Comment for planning application 23/01080/OUT

Application Number	<input type="text" value="23/01080/OUT"/>
Location	<input type="text" value="Land North Of Bicester Avenue Garden Centre Oxford Road Bicester"/>
Proposal	<input type="text" value="Variation of Condition 4 (approved plans and documents), Condition 30 (highway design) and Condition 34 (employment floor space limit) of 17/02534/OUT relating to the erection of a business park of up to 60,000 sq.m (GEA) of flexible Class B1(a) office / Class B1(b) research & development floorspace (now under Use Class E); associated vehicle parking, landscaping, highways, infrastructure and earthworks (Original Application accompanied by an Environmental Statement)"/>
Case Officer	<input type="text" value="Tom Webster"/>
Organisation Name	<input type="text" value="Katherine Longthorp"/>
Address	<input type="text" value="3 Banbury Road, Bicester, OX26 2HH"/>
Type of Comment	<input type="text" value="Objection"/>

OXFORD ROAD / MIDDLETON STONEY MINI ROUNDABOUT MITIGATION MEASURES

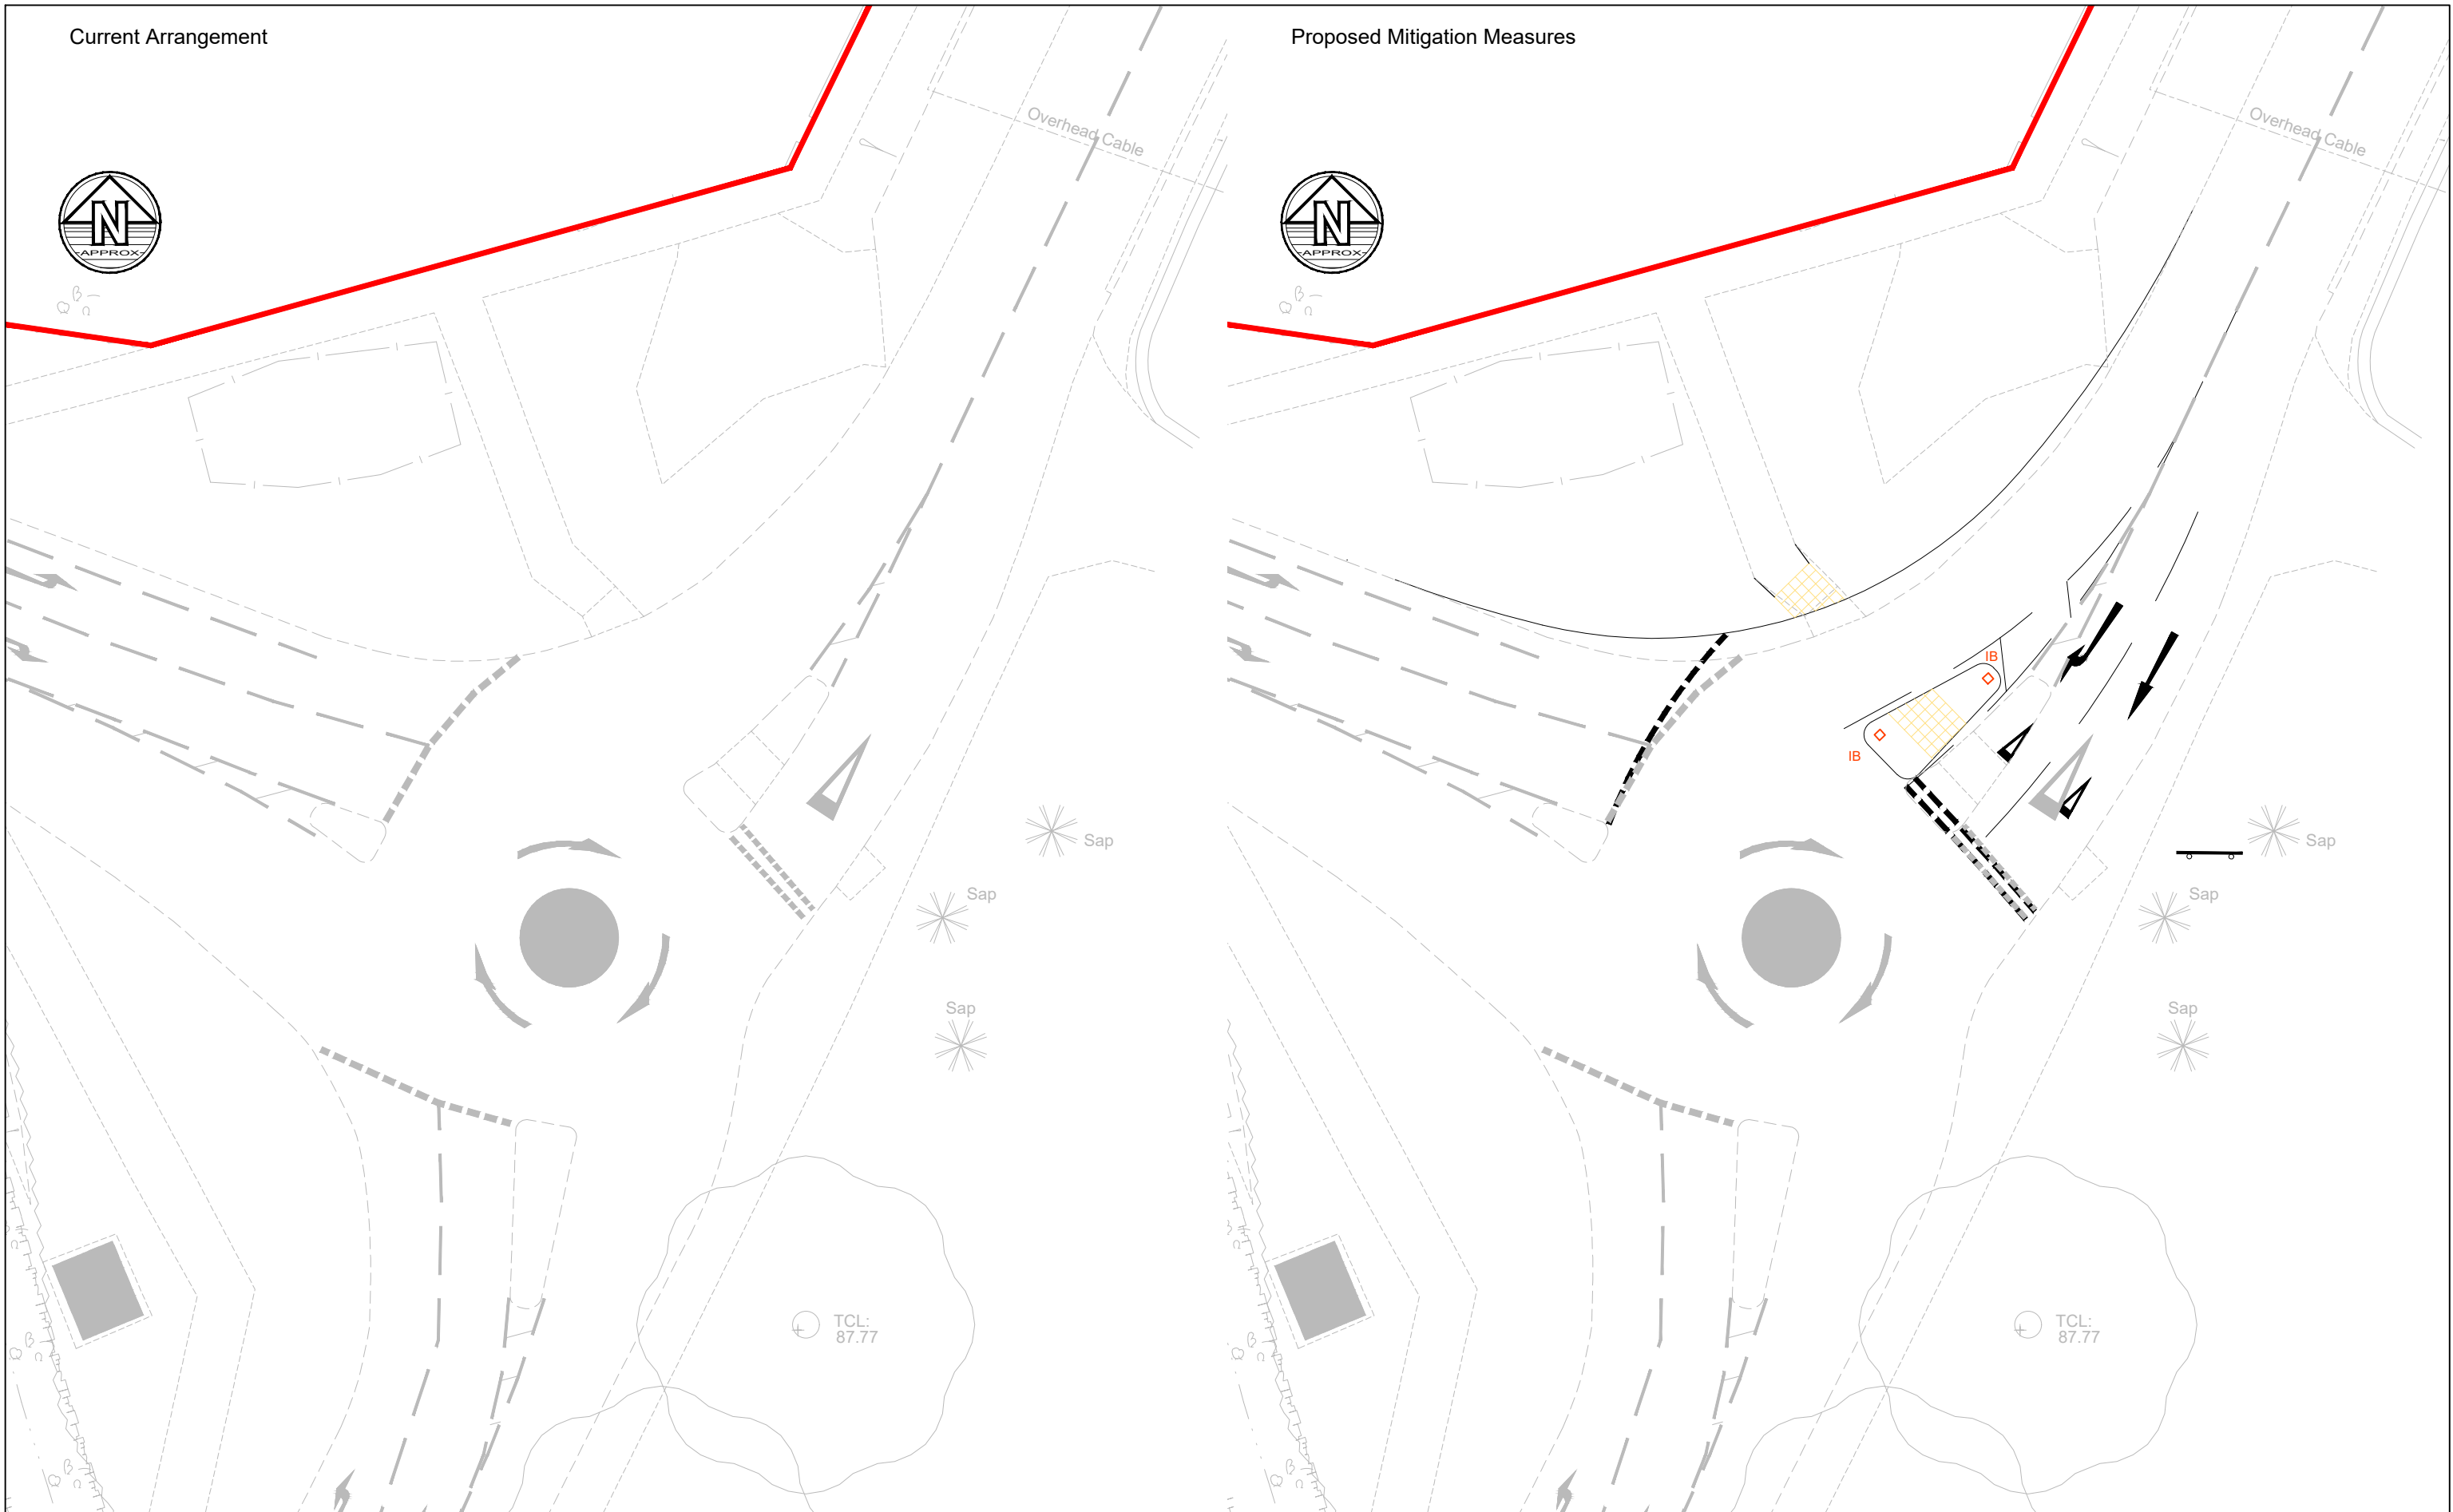
Type	<input type="text" value="neighbour"/>
Comments	<input type="text" value="I do not see how adding separate crossings for pedestrians and cyclists is warranted. Cyclists should dismount and cross with the pedestrians, having a straight dedicated crossing encourages them to cross whenever they want even if cars are coming, many cyclists act like they own the road and act without due care and attention.
In addition I have concerns regarding the suitability of the pedestrian crossing. Does it comply with the Equality Act 2010? It is currently not wide enough for two mobility scooters/wheelchairs to pass on and it is debatably whether the turning angle is adequate because mobility scooters have terrible turning angles.
Given that there is already inadequate space with just the two crossing sections adding a third does not seem physically possible without losing road lanes (which the diagram does not appear to do) or making the pedestrian crossings even narrower.

Please put more thought into accessibility for the disabled, cyclists have flexibility, wheelchair users do not."/>
Received Date	<input type="text" value="03/11/2023 08:53:00"/>
Attachments
